**KIRKLEES METROPOLITAN COUNCIL
INVESTMENT & REGENERATION SERVICE**

DELEGATED DECISION TO DETERMINE PLANNING APPLICATIONS

Reference No:	2024/62/91288/W
Site Address:	4, Sycamore Rise, Wooldale, Holmfirth, HD9 7TJ
Description:	Demolition of existing conservatory and erection of single storey rear extension with new openings to existing elevations
Recommending Officer:	Joanna Rednall

HOUSEHOLDER DELEGATED REPORT

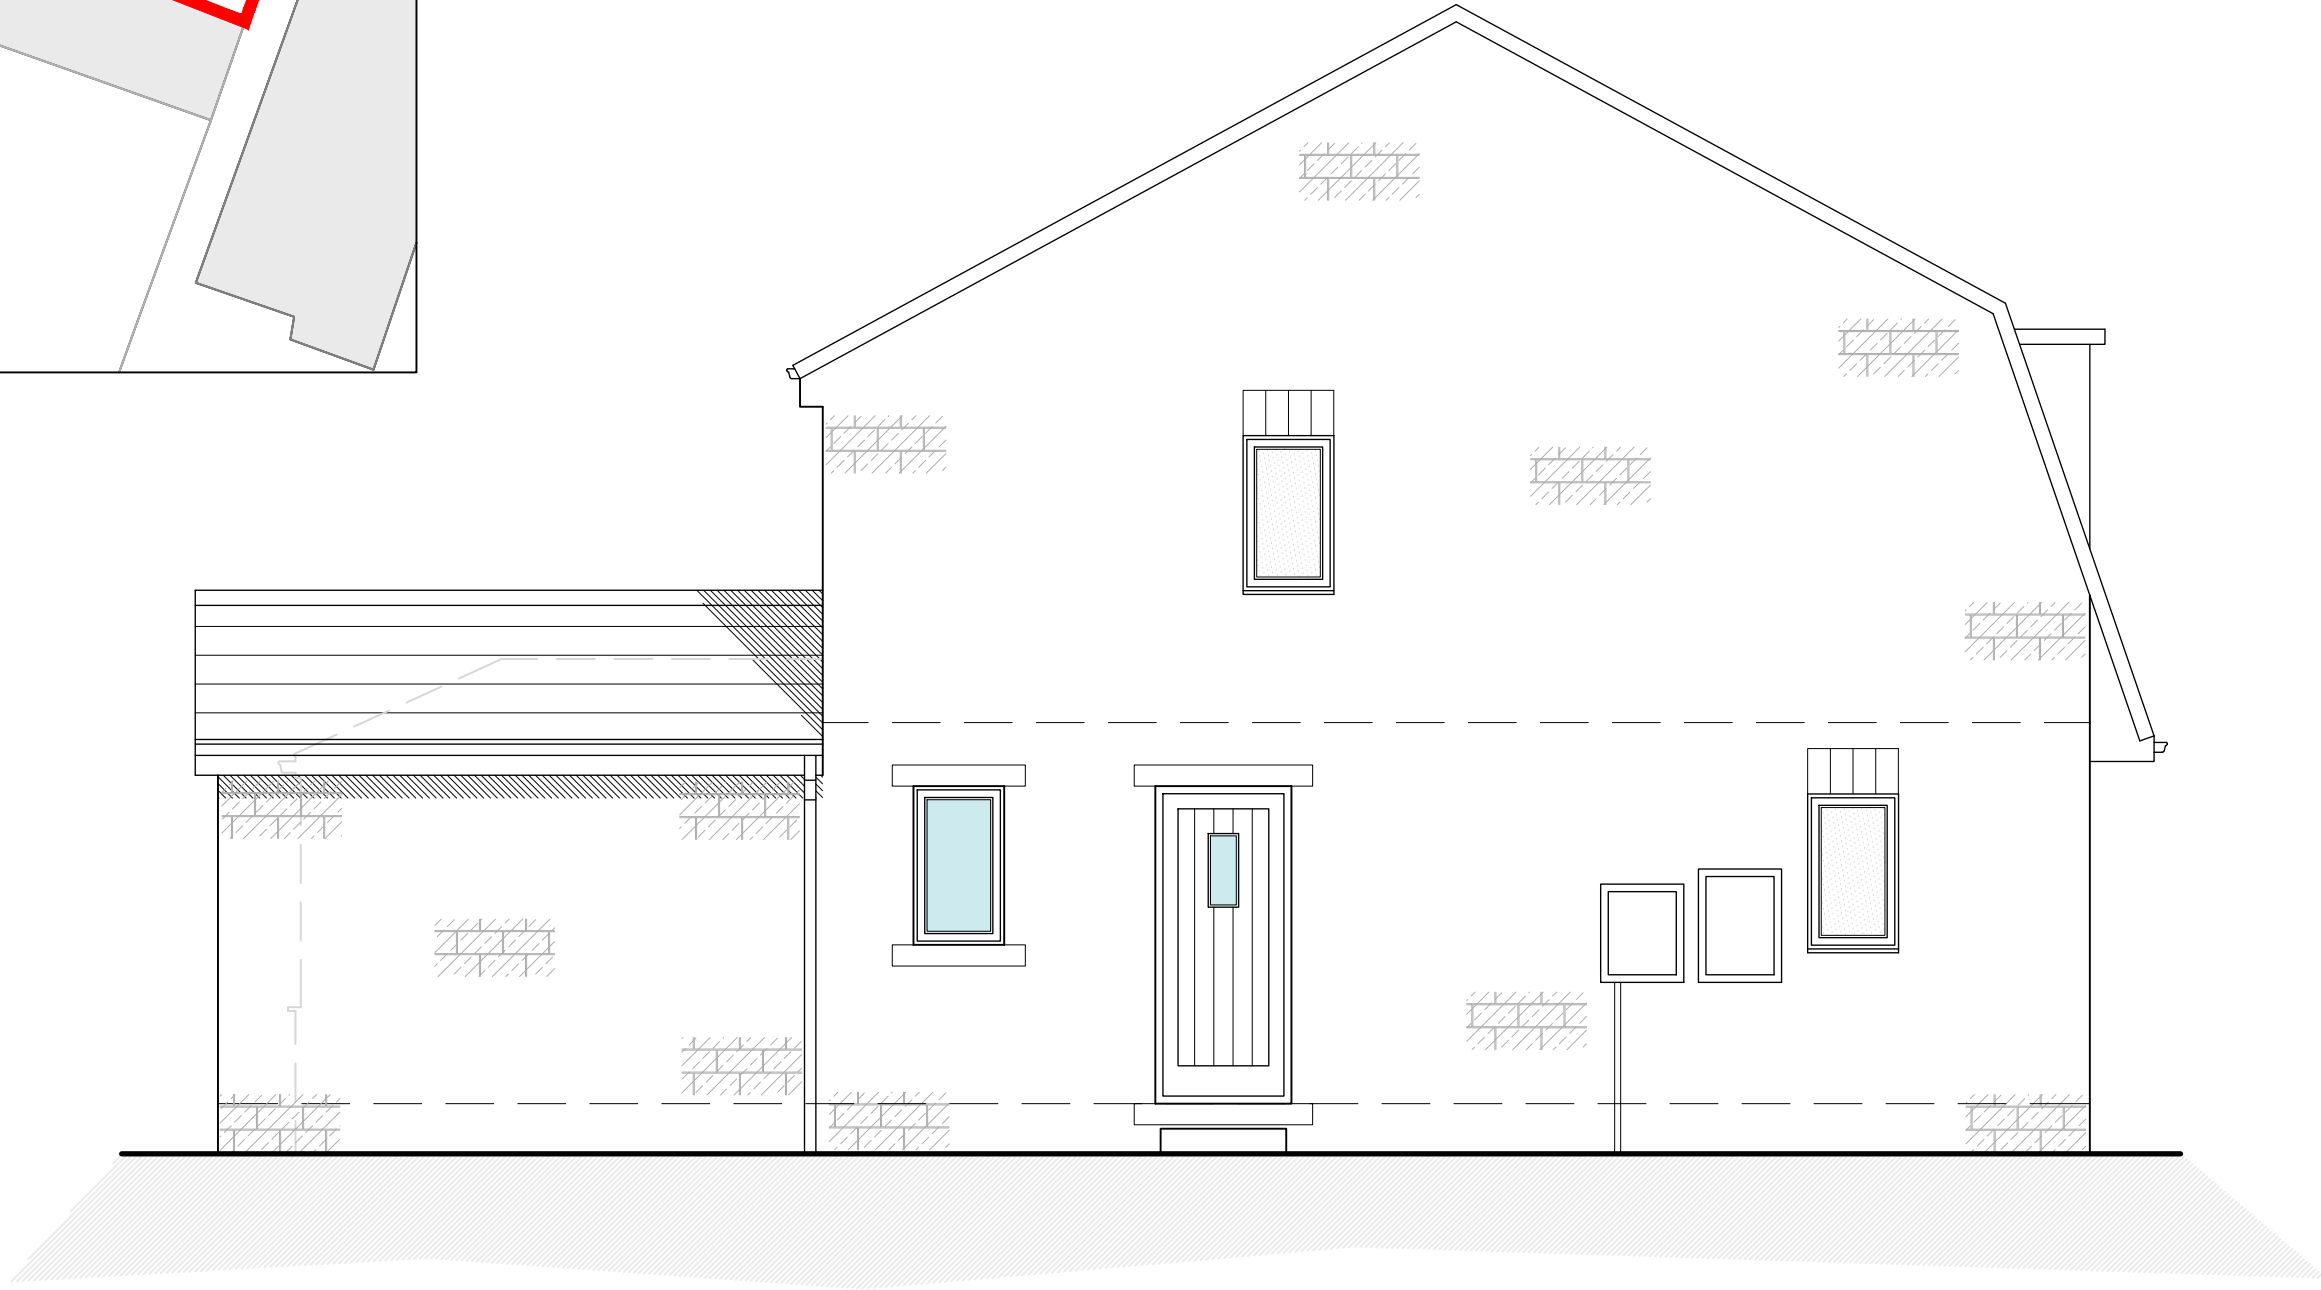
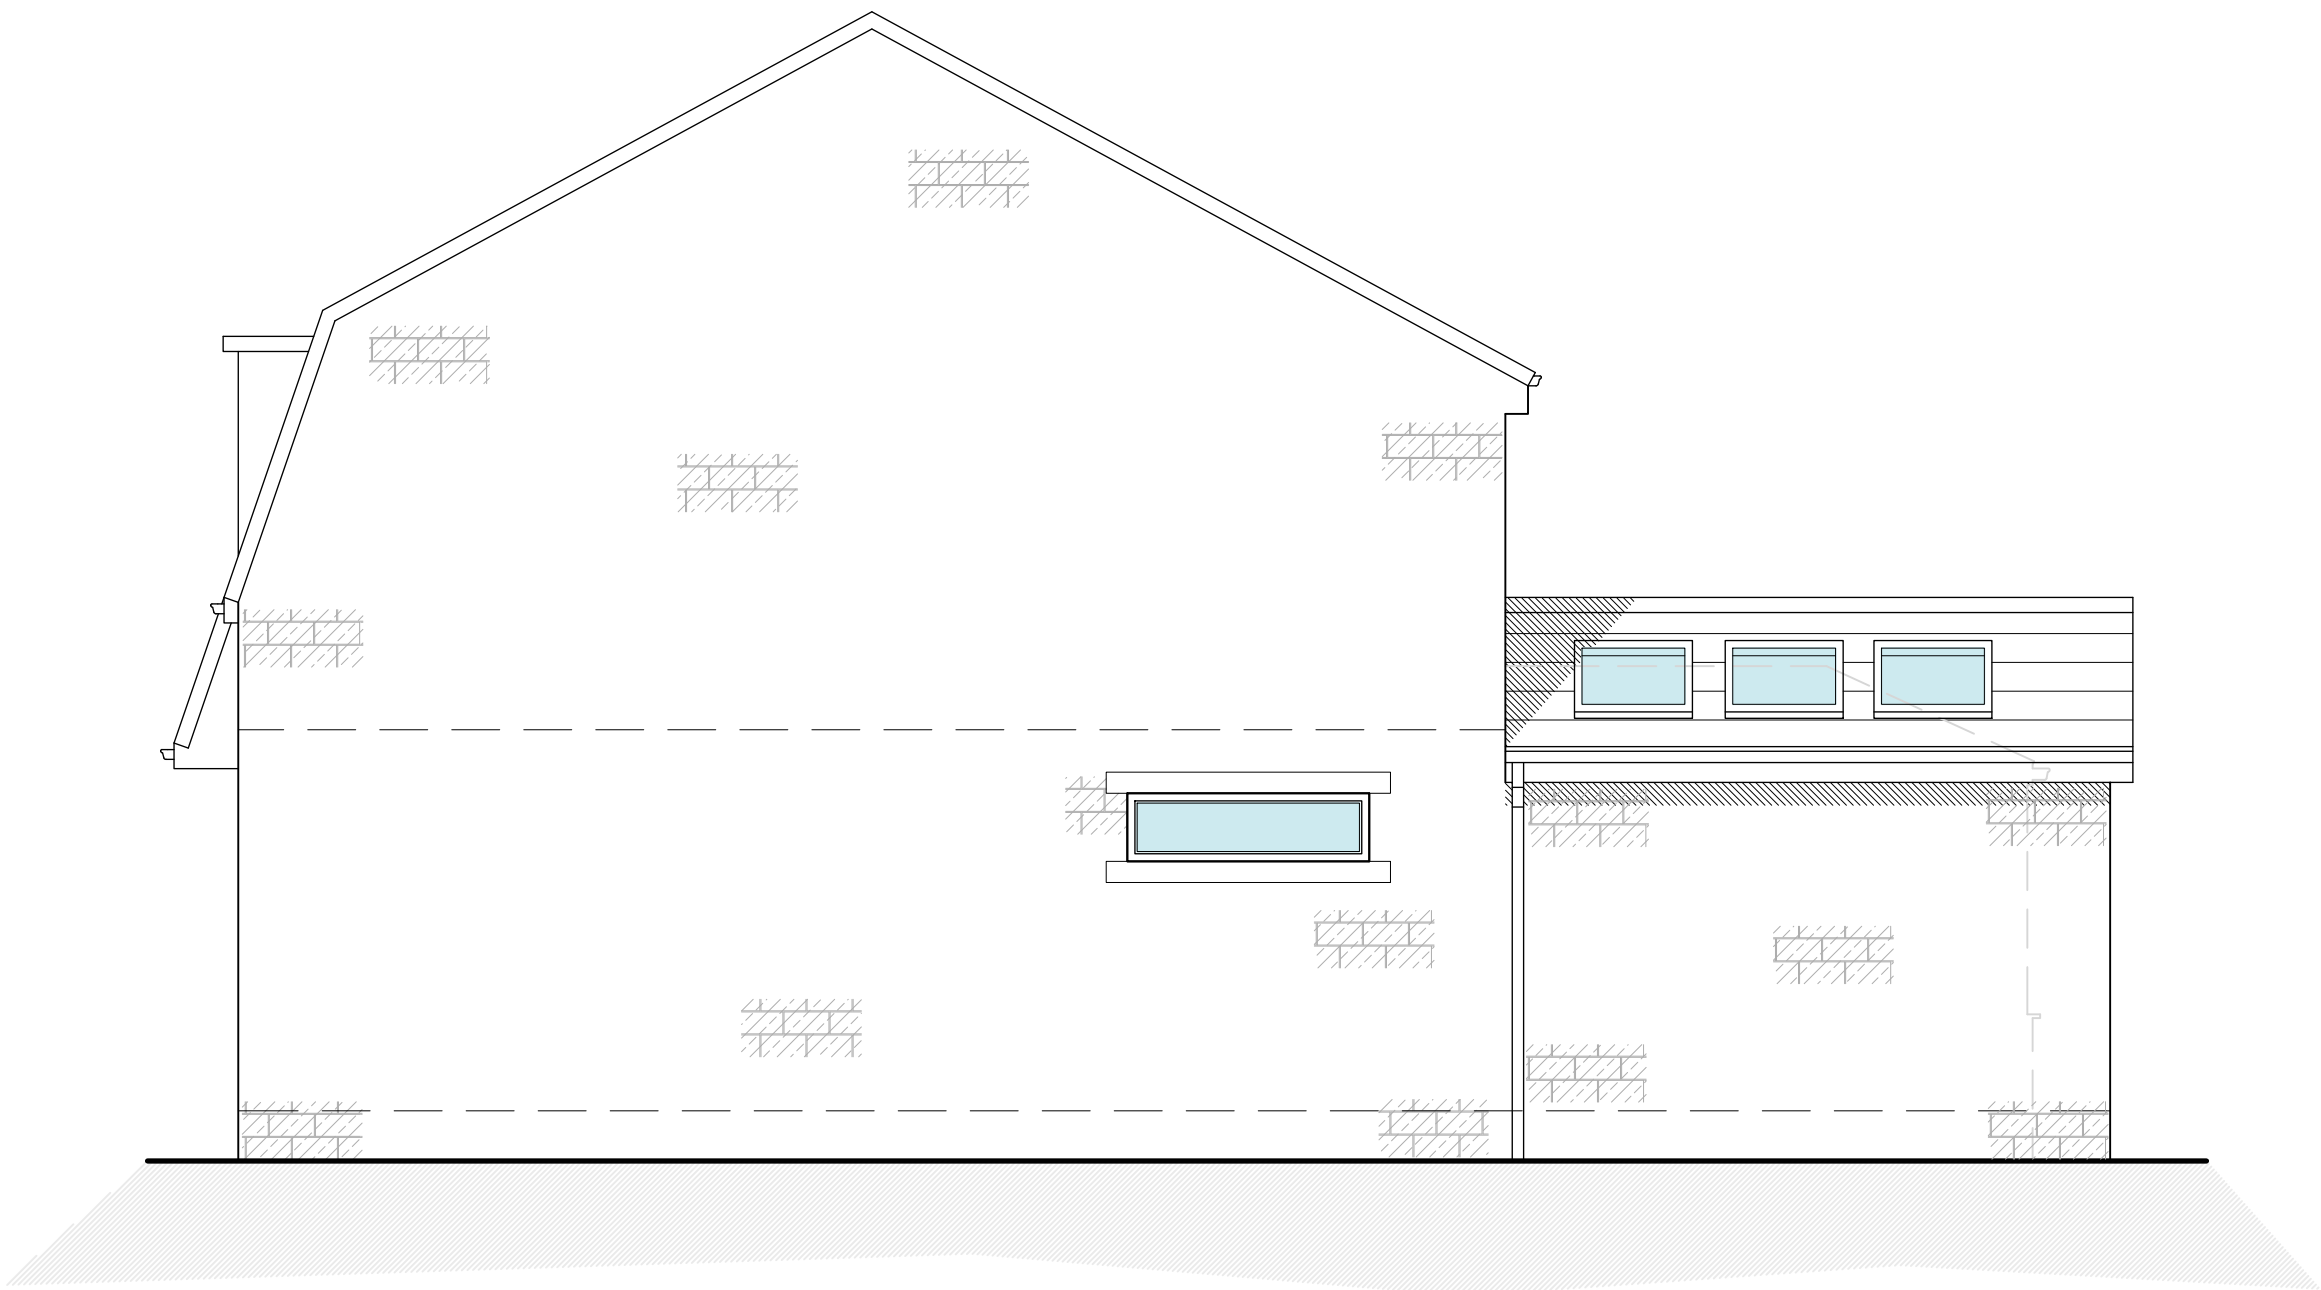
- ~4 metre projection
- ~4.7 metre width
- ~2.5 metre eave height
- ~3.7 metre ridge height

The single storey extension would extend across the rear elevation and lie flush with both side elevations of the host. Internally, the extension would provide an extended kitchen and dining space.

The exterior walls would be constructed from artificial stone. The roof would be gable in design infilled with concrete tiles. The proposed materials would match the host property.

With regard to fenestration, the extension proposes bi-folding doors within the rear elevation with a pair of windows to the side. There would be three rooflights within the side/ southwest facing roofplane of the extension.

New openings to the existing dwelling are proposed as part of the works. This consists of a high window within the side/south west ground floor elevation, as well as a window within the northeast facing elevation.

where they exceed 3m in length the eaves height should generally not exceed 2.5 meters	The eaves would be 2.5m in height.	
retain a gap of at least 1 metre from a property boundary, such as a wall, fence or hedge	The extension would retain a ~0.5m gap from the side/southwest facing elevation.	Although against SPD guidance, the extension is following an established relationship with the boundary. There would be no design benefit in setting the extension in by a whole metre and it would be unreasonable of the LPA to request such an amendment in this case.

Height, scale and massing	<ul style="list-style-type: none"> • KDP 1 and 2 of the SPD • Policy LP24 Design (a), (c) and (d) of the KLP • Policy 1 & 2 of the HVNDP • Chapter 12 of the NPPF 	Single storey and full width of rear elevation – appears proportionate when viewed side elevations.	✓
Facing materials and detailing	<ul style="list-style-type: none"> • KDP 9 of the SPD • Policy LP24 Design (d) (iii) of the KLP • Policy 1 & 2 of the HVNDP • Chapter 12 of the NPPF 	Materials to match – stone for the walls and concrete tiles for the roof. Proposed openings appear acceptable from a visual perspective.	✓
Roof style	<ul style="list-style-type: none"> • KDP 1 and 2 of the SPD • Policy LP24 Design (a), (c) and (d) of the KLP • Policy 1 & 2 of the HVNDP • Chapter 12 of the NPPF 	Gable in design to complement host.	✓
Window proportions	<ul style="list-style-type: none"> • KDP 1 and 2 of the SPD • Policy LP24 Design (a), (c) and (d) of the KLP • Policy 1 & 2 of the HVNDP • Chapter 12 of the NPPF 	Full height openings within the rear elevation considered acceptable. Additional openings within side and rear elevations are of acceptable size and white PVCu to match existing openings within the host.	✓

- 25, New Mill Road – located to the rear of the application site. A separation distance of ~10 metres is achieved between this neighbour and the proposed extension. Whilst the extension would be closer to No.25 than the existing conservatory, the extension is limited in height at a maximum of ~3.7m with an eave’s height of ~2.5m. Given the limited height of the works, existing boundary treatment combined with the blank side elevation of No.25, the extension would not cause detrimental harm to overlooking/ overbearing/ overshadowing.
- 2, Sycamore Rise – located to the south of the application site. Given the single storey nature of the works as well as it been set off the immediate neighbouring boundary, the works would cause no detrimental impacts of overbearing/overshadowing. One high window is proposed within the south-facing elevation that serves a workspace.
